Recommendation Report for Planning Permission for Works or Extension to a Dwelling

REF NO: BR/109/26/HH

LOCATION: 8 Greenwood Avenue
Bognor Regis
PO22 9EN

PROPOSAL: Construction of single storey rear extension to replace existing conservatory.

FOR		
MR J. SATTURLEY		
SITE		
8 GREENWOOD AVENUE, BOGNOR REGIS, WEST SUSSEX. PO22 9EN		
TITLE		
PROPOSED EXTENSION BLOCK PLAN		
SCALE	DRAWN	DRAWING NO.
1: 500 © A3	AH 03/26	01B REV. A

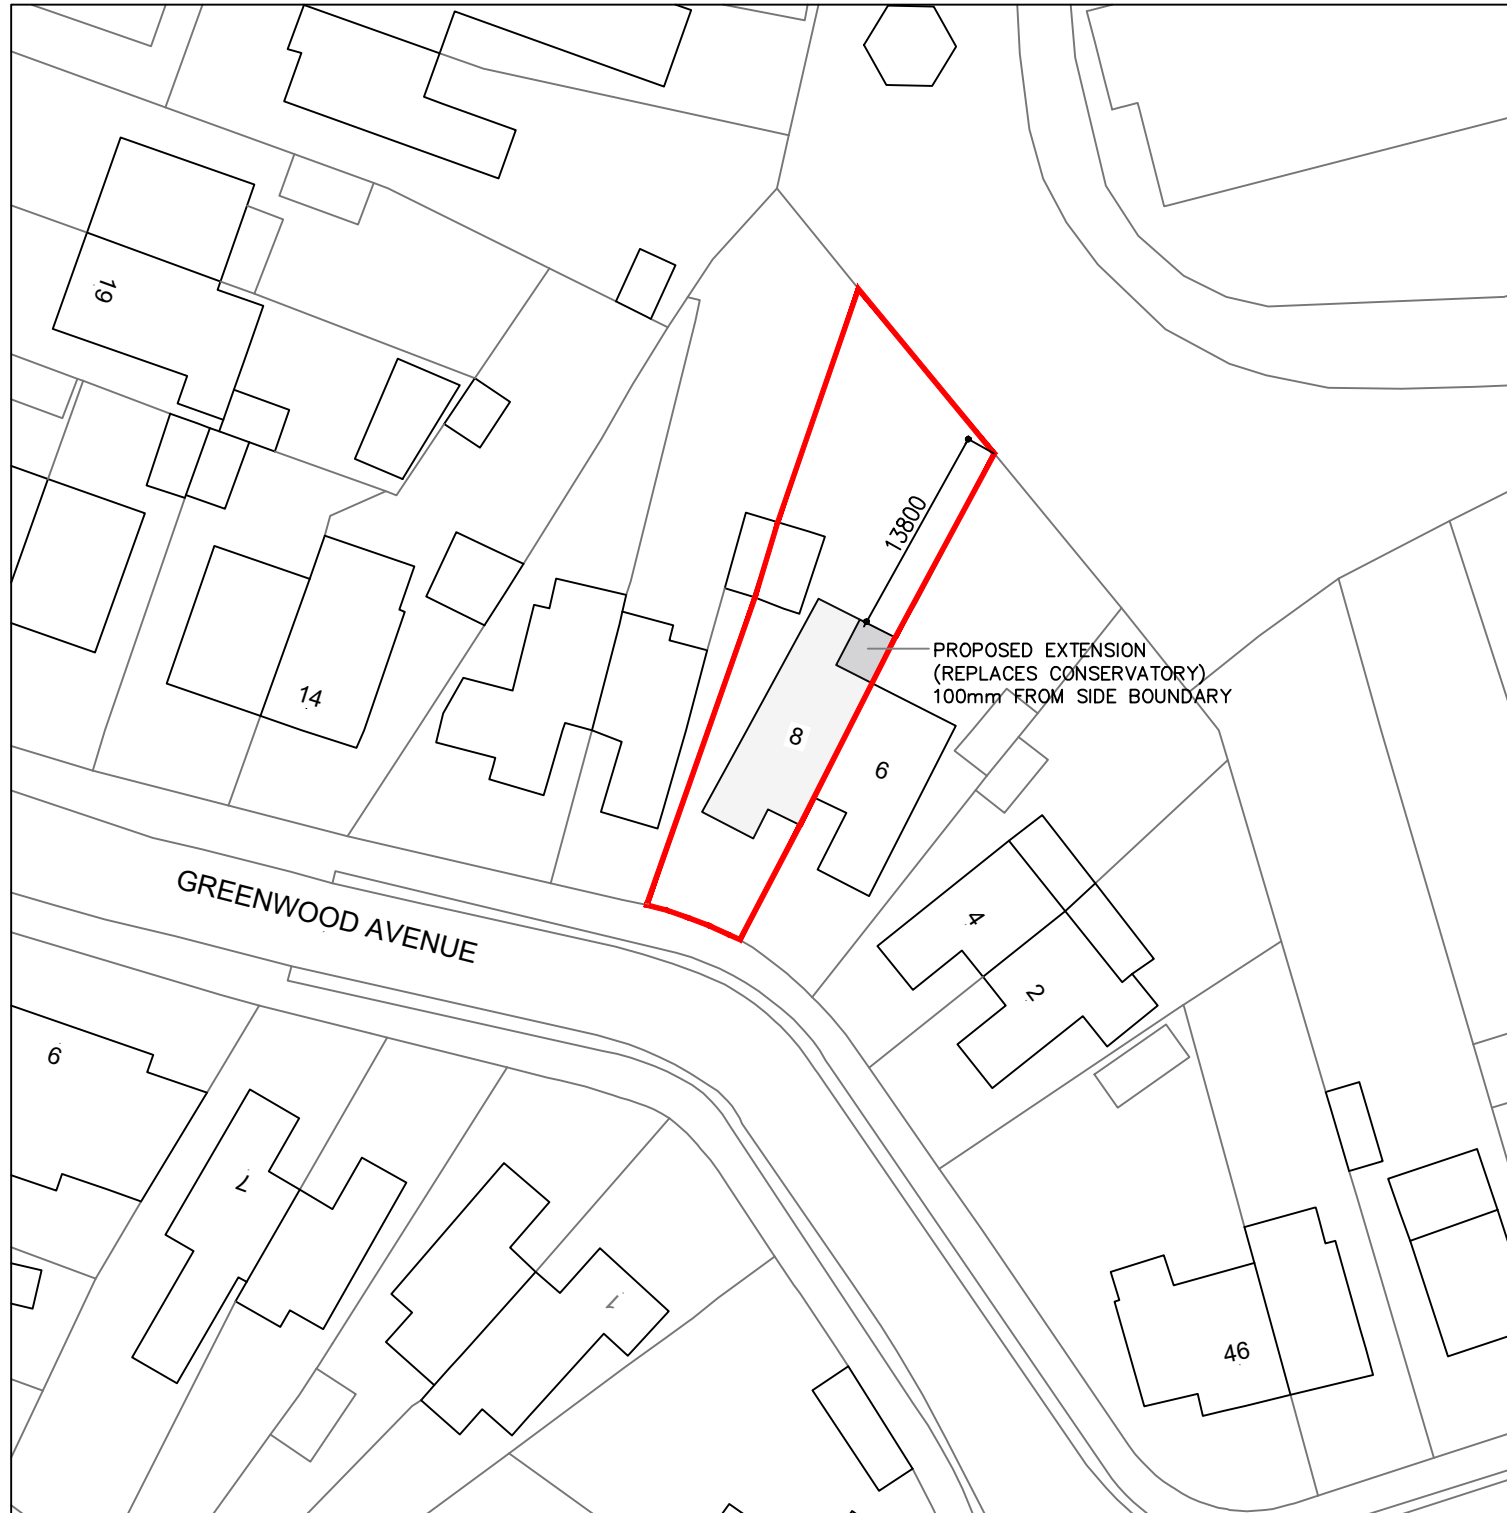
The proposed single-storey rear extension would have a width of 6m and a depth of 3.9m. Although the depth would exceed the Arun Design Guide (ADG) guidance of 3.3 metres, a garden depth of approximately 13.8 metres would be retained, and it is noted that the extension would replace a conservatory of equal depth. The flat roof would have a height of 3.5m and an eaves height of 3.2m. While the proposed roof would be higher than the existing conservatory, this increase would not appear visually harmful. Similar rear extensions are also present within the surrounding area such as at No.52 and No.58 Orchard Way. The proposal would therefore not harm the character or visual amenity of the host dwelling.

FOR MR J. SATTURLEY		
SITE 8 GREENWOOD AVENUE, BOGNOR REGIS, WEST SUSSEX. PO22 9EN		
TITLE PROPOSED EXTENSION TO REPLACE CONSERVATORY PLANS & ELEVATIONS		
SCALE 1:100 @ A3	DRAWN AH 03/26	DRAWING NO. 03 REV

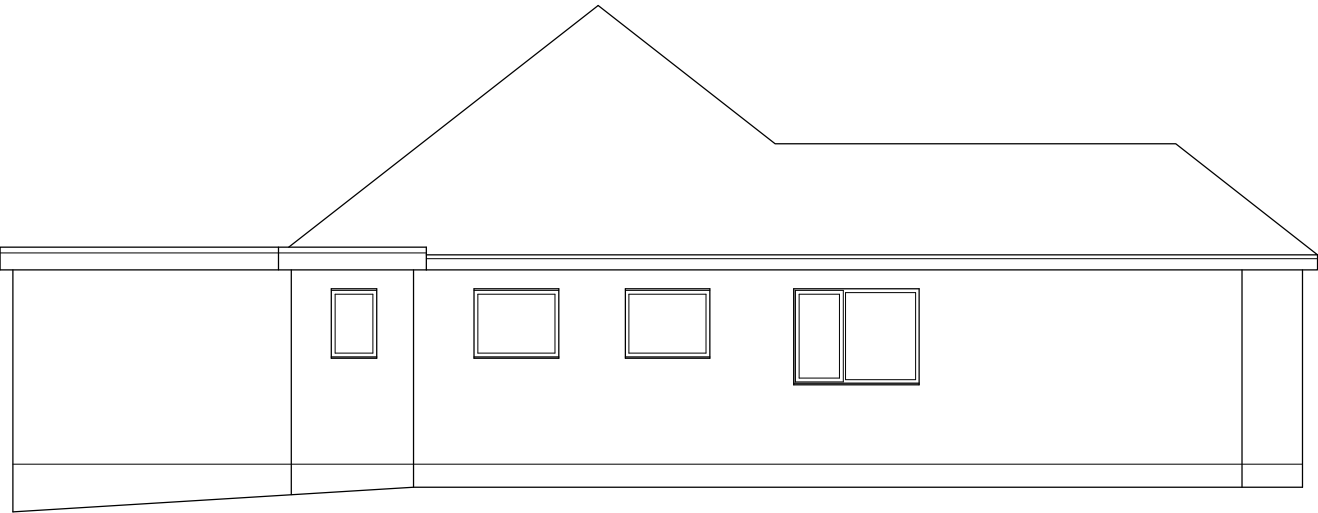
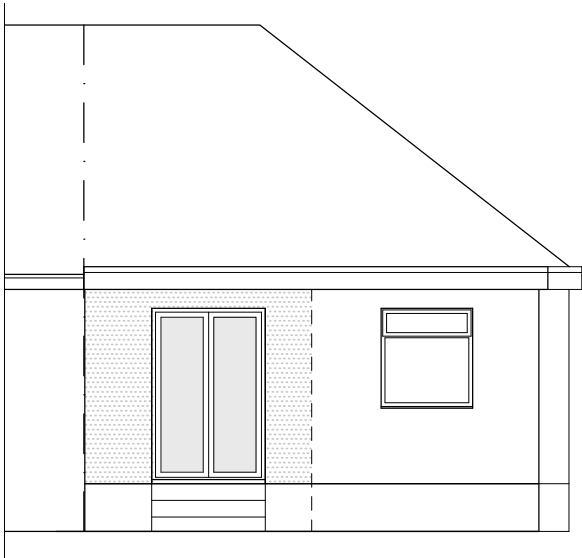
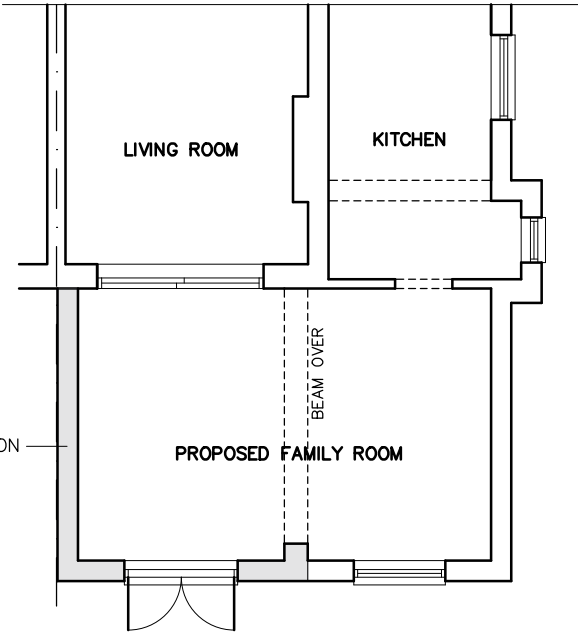
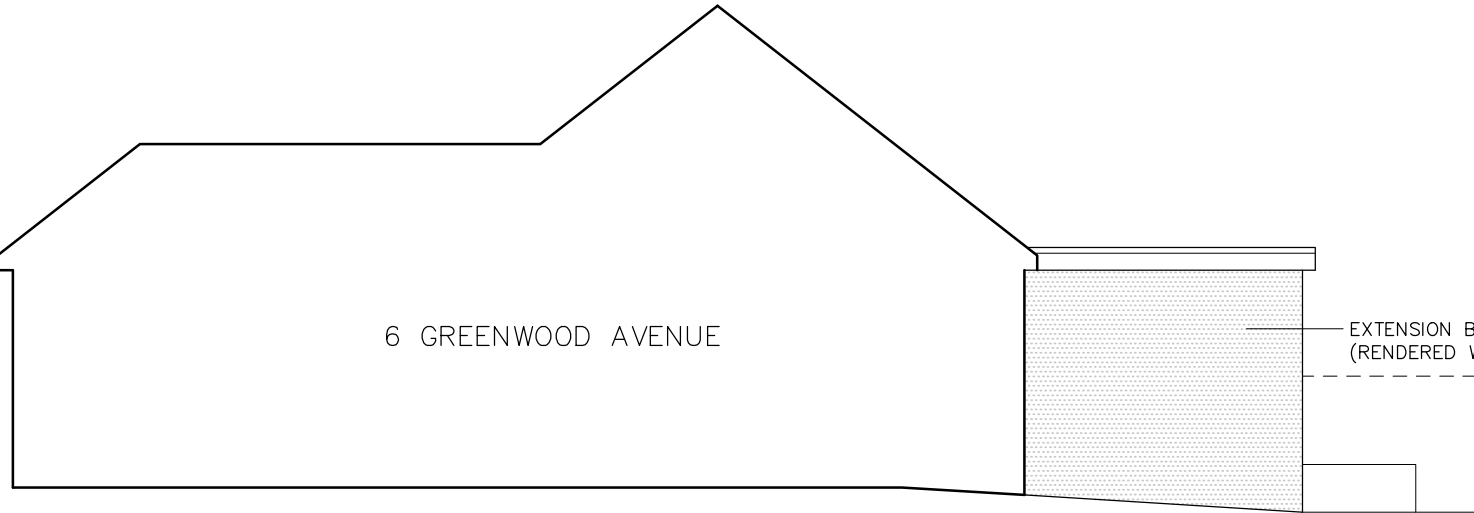
Fenestration would be contained to the rear elevation and would include a two-casement window and a set of double doors. Materials and uPVC fenestration would match the existing dwelling. The use of matching materials would allow the extension to integrate acceptably with the host dwelling, in accordance with Arun Local Plan (ALP) policies D DM1 and D DM4.

The proposed single-storey rear extension would replace the existing conservatory and would be constructed up to the eastern boundary with the neighbouring property. The extension would extend in line with the host dwelling's existing rear extension and would be approximately 0.5 metres higher than the conservatory it replaces. As such, some limited additional overshadowing would occur to the neighbour to the east. However, given the existing relationship between the properties, boundary treatment, flat roof design and overall height, the proposal would not result in unacceptable overshadowing or overbearing impacts on neighbouring occupiers.

The proposed fenestration would be isolated to the rear elevation and would have an outlook over the host dwelling's amenity space and therefore would not result in any overlooking or loss of privacy.
